This document is intended to fulfil the action assigned to Mark Hawes in the Open Floor Hearing on the 22<sup>nd</sup> February. The action involves responding to the Applicant response submitted via REP3-026 Highways England Deadline 3 Submission - 7.15 Applicant's Responses to Written Representation (table 1-6). Due to the inclusion of large pictures this document has been split into two parts. This document is part 2 and is intended to be read after part 1.

#### **Follow-up response to deadline 3 comments from the Applicant – Reference 6**

Drawing Title: Figure 6.7 Noise Level Benefits from Proposed Noise Barrier Four

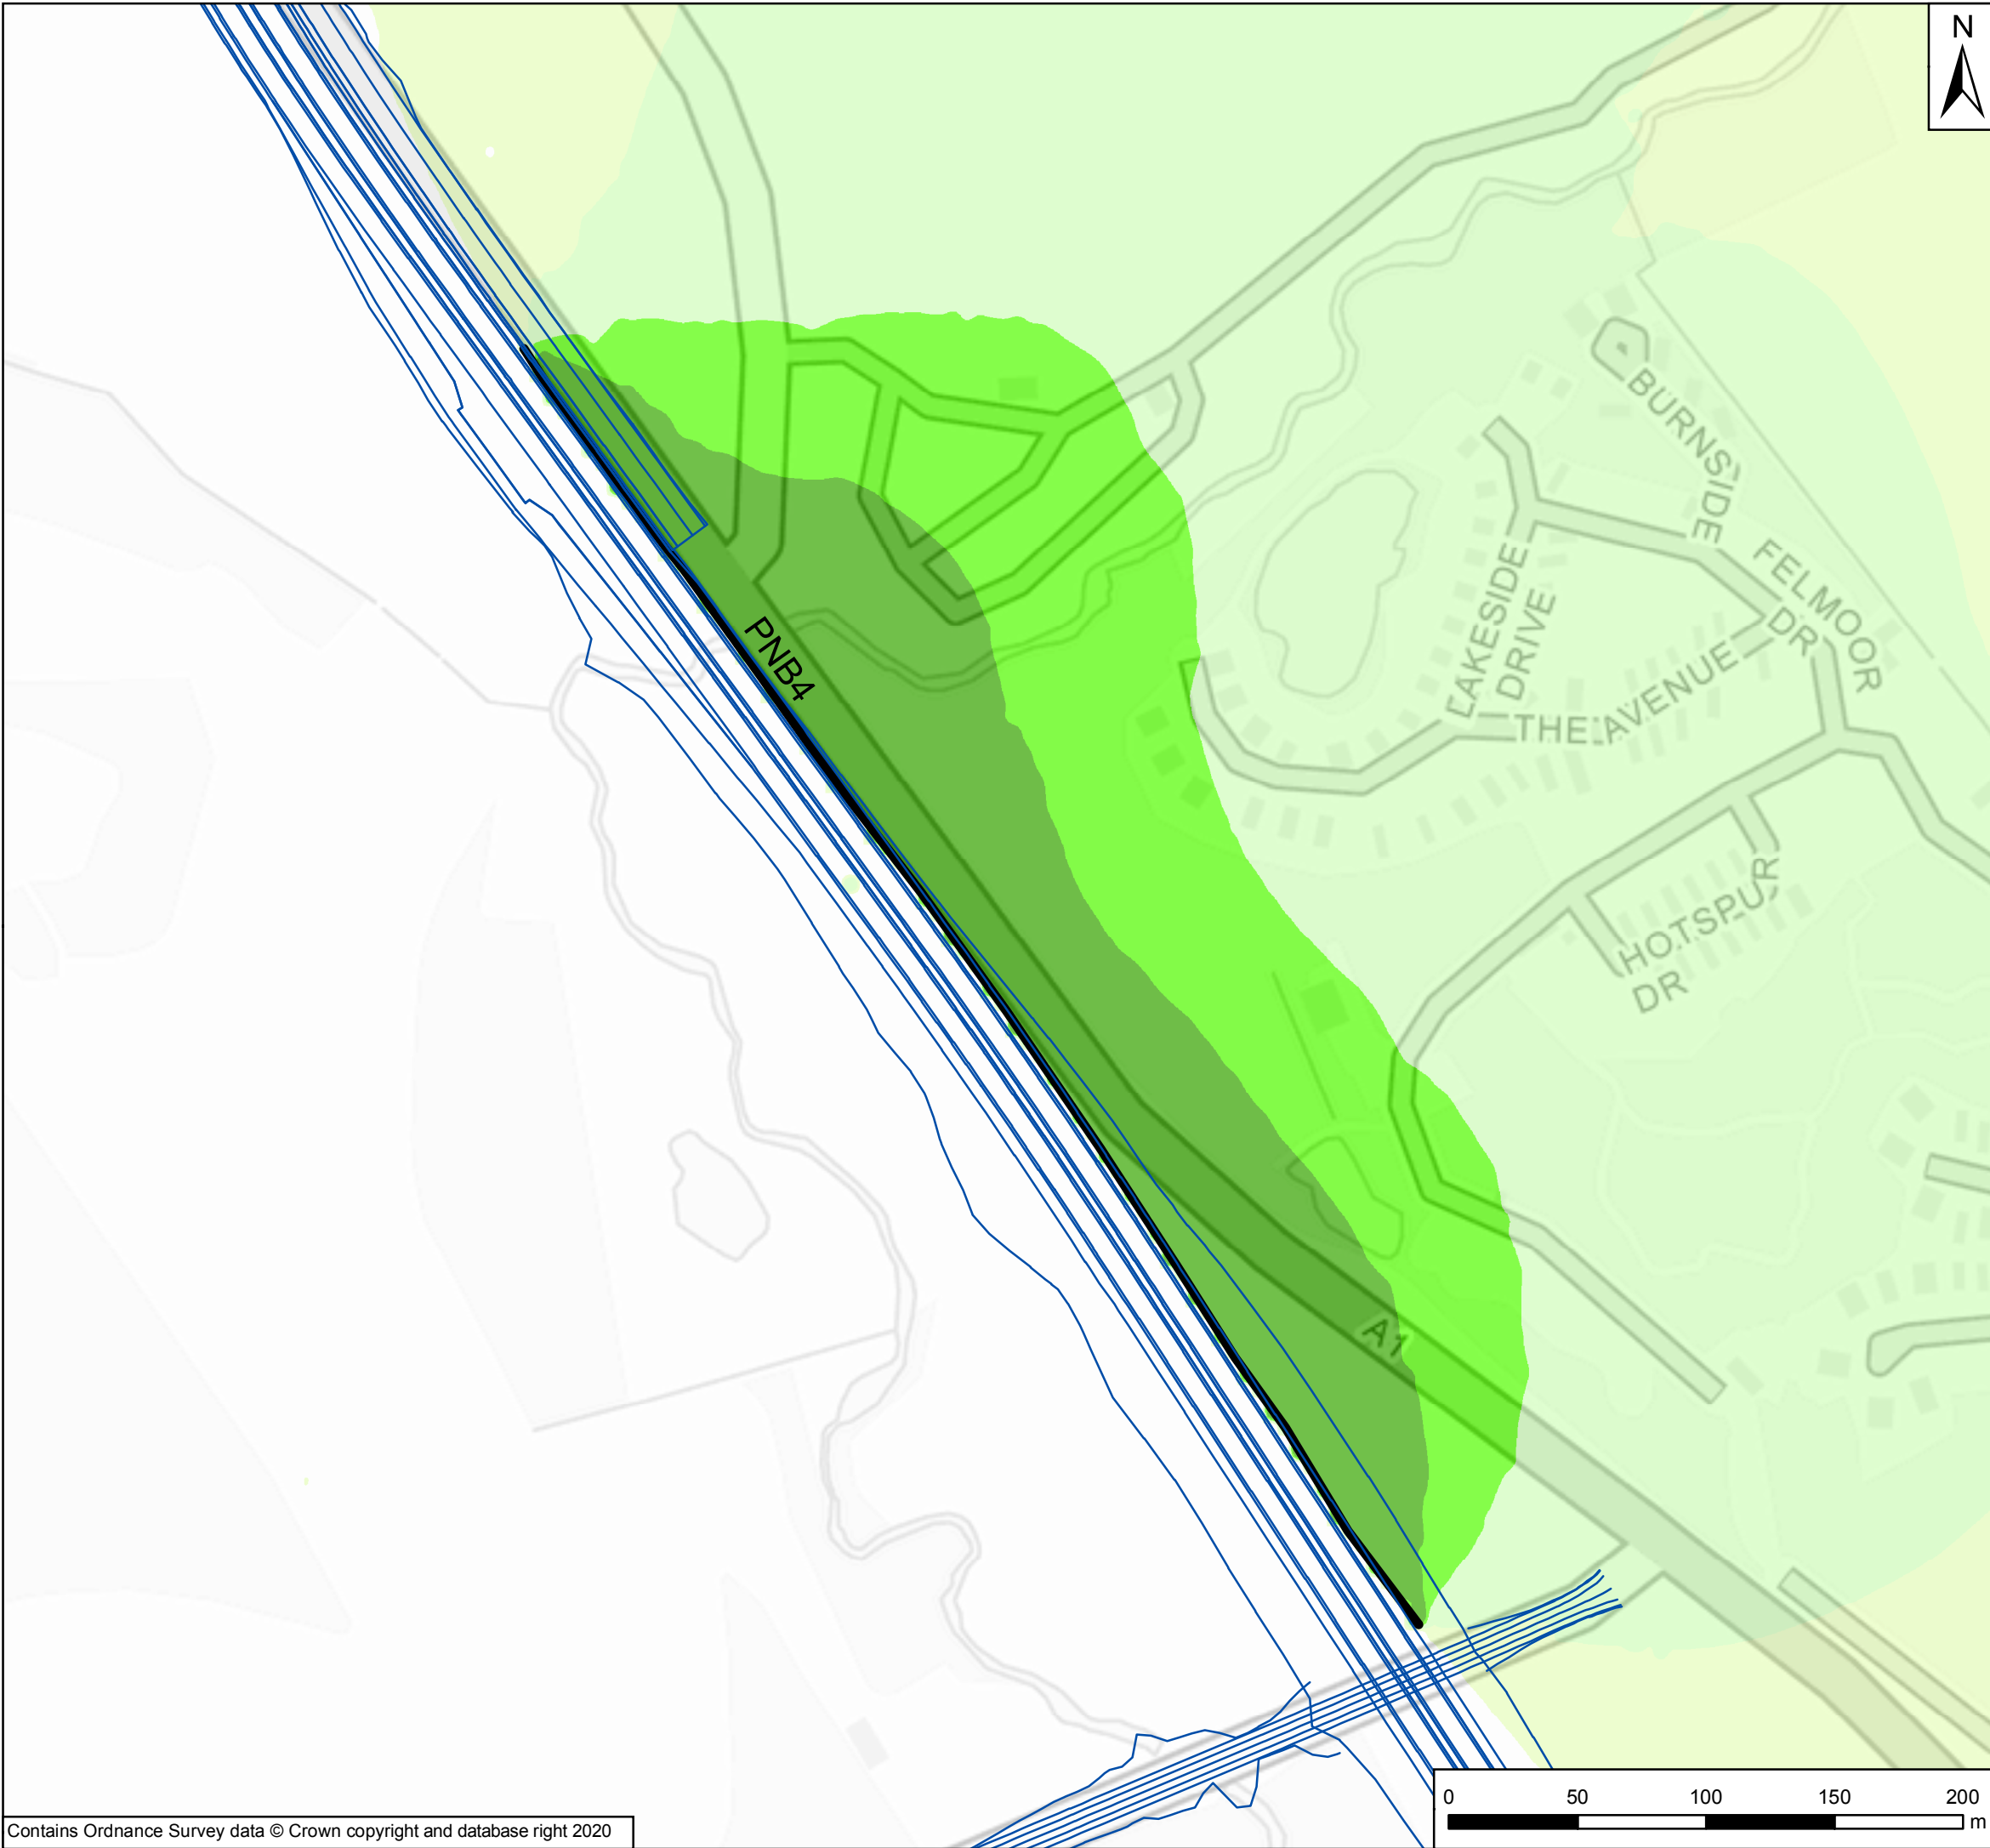
1. Point 1 from the Applicant. We welcome confirmation that the noise barrier will be constructed but disappointed to read that cost is the only reason why it does not extend to the end of the property boundary. The response from the Applicant suggests that their sole focus is to protect the noise impact upon the buildings, with little consideration or provision for its impact within the garden area.

5. Point 6 from the Applicant. It is reassuring to read that the Applicant did consider other mitigation measures but disappointing that none were taken forward. In looking at the possibility of an earth bund the applicant suggests that this is not feasible due to the lack of space. We are surprised by this conclusion as there is a sizeable area at the end of the noise

barrier which would be ideal for an earth bund. I would welcome the opportunity to explore this further with the Applicant.

1. Point 1 from the Applicant. We welcome confirmation that the noise barrier will be constructed.
2. Point 4 from the Applicant. Given the significant adverse impact it is particularly disappointing to read that cost is the only reason for not providing noise barrier coverage to the full length of the property. As a full-length barrier would also help mask some of the visual impact, I am surprised that this was not also factored into the cost benefit analysis. Similarly, having made a decision to shorten the barrier it is disappointing that other cheaper options are not provided.

1. Point 3 from the Applicant. As previously highlighted the assessment the focus on noise impact is solely on the building and not the garden where we like to spend most of our leisure time. In acknowledging that the noise barrier is the only mitigation it stands to reason that those areas not sheltered by the barrier will be a lot noisier. For example, the point of access to the property will be circa 20 metres from the dual carriageway and totally exposed to the road and increased noise.

Figure 1 – DCO Application proposed PMA Route

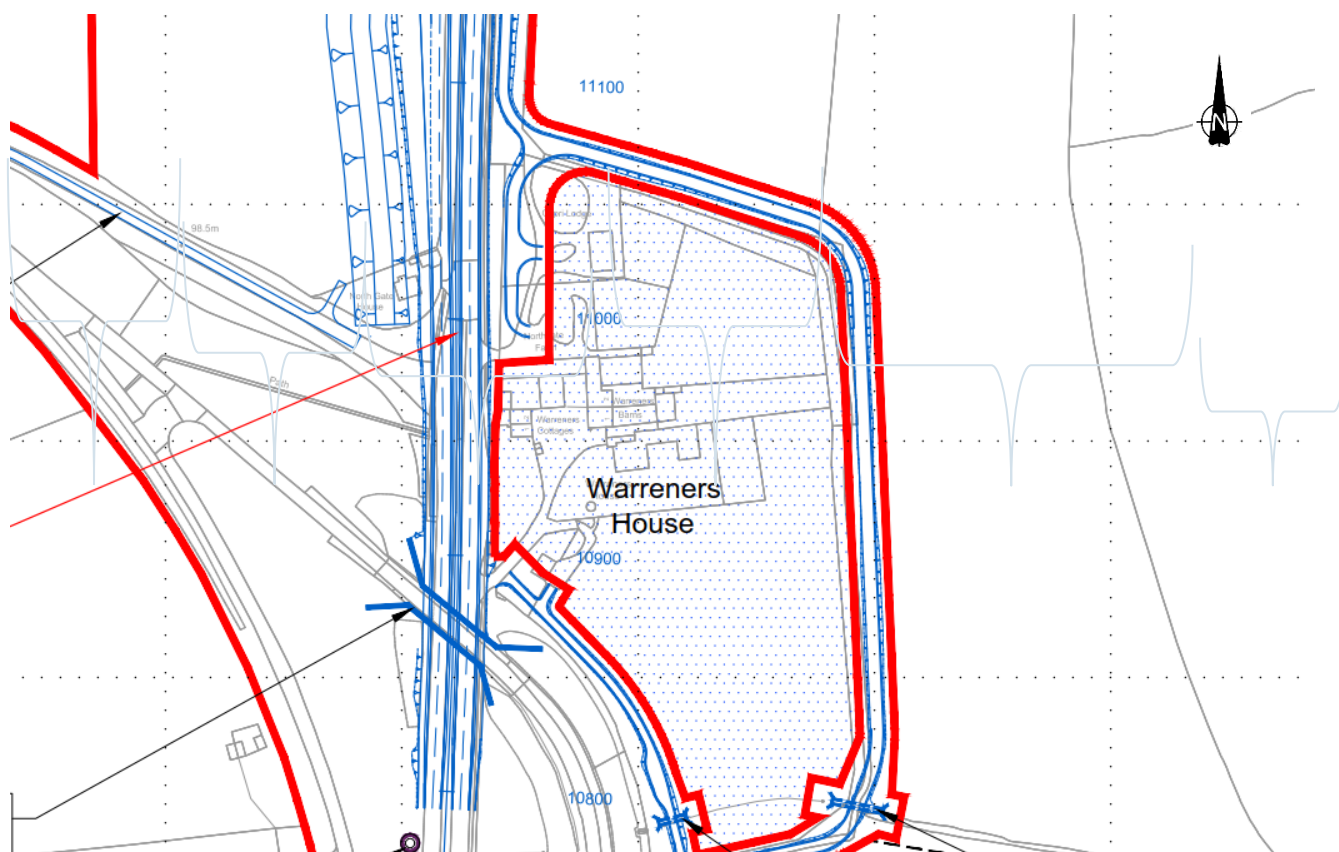
2. The noise from vehicles using the new access road will intermittently spoil the enjoyment of this area. This noise will be noticeably louder than any other experienced in the area. Based upon current usage this is expected to exceed 20 vehicle journeys a day.

The following two photographs are taken from the South East corner of the property. This view will change dramatically when the new PMA is constructed. The intended route of the road is along the trees and then across the immediate foreground. Following construction, the road will be very much in the foreground of this view. When the hedgerow matures the road will become hidden but the hedgerow will block the outlook across the field.

The following photograph is taken from the North East corner of the property looking to the North. This view will change dramatically when the new PMA is constructed. The intended route of the road is directly across this view blocking any outlook
